Geotechnical Engineering Study
Pearsons Ministries Facility Improvements
Green Mountain Falls, Colorado

Yeh Project No.: 219-217

July 22, 2019
Revised November 21, 2019

PCD File No. PPR1933

EAST POND OUTLET STRUCTURE PROFILE DETAIL
N.T.S.

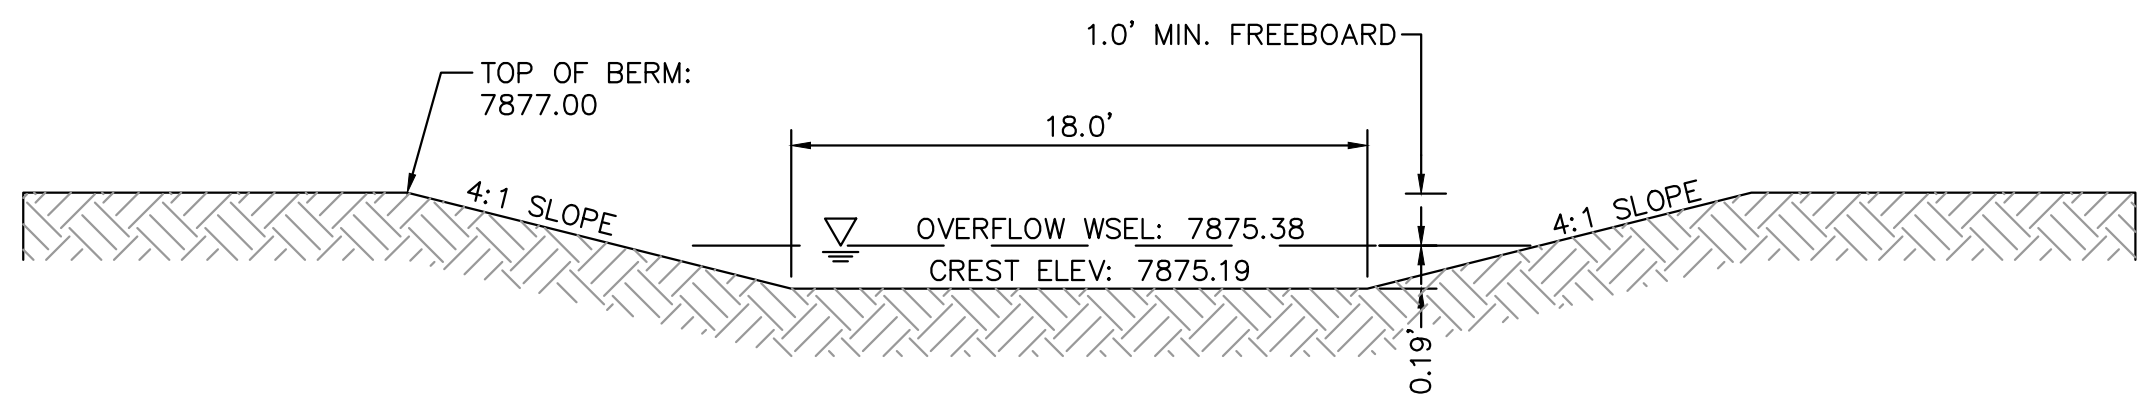
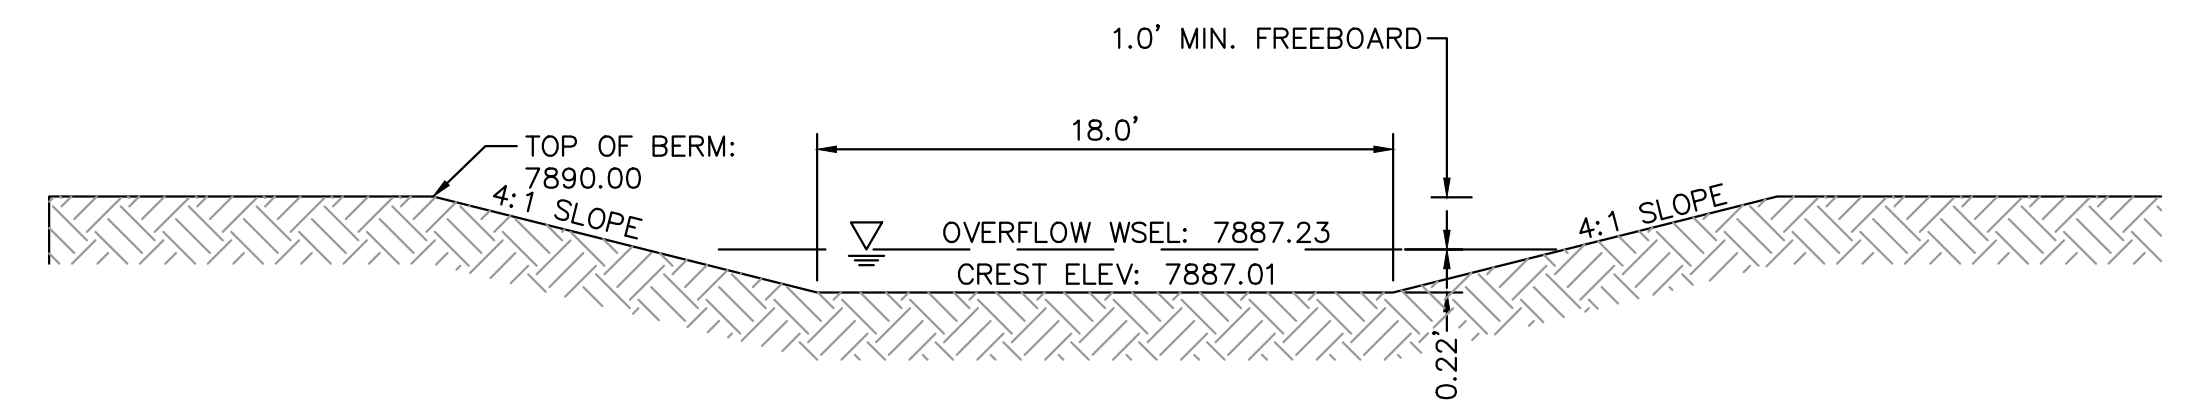
This report does not provide recommendations for the detention facility. Per Chapter 11, section 11.3.3 of the El Paso County Drainage Criteria Manual a Geotechnical report with recommendations for the foundation preparation and embankment construction shall be submitted with the complete design analysis for all permanent detention facilities. Please provide the appropriate recommendations for the detention facilities per DCM Vol. 1 Section 11.3.3.
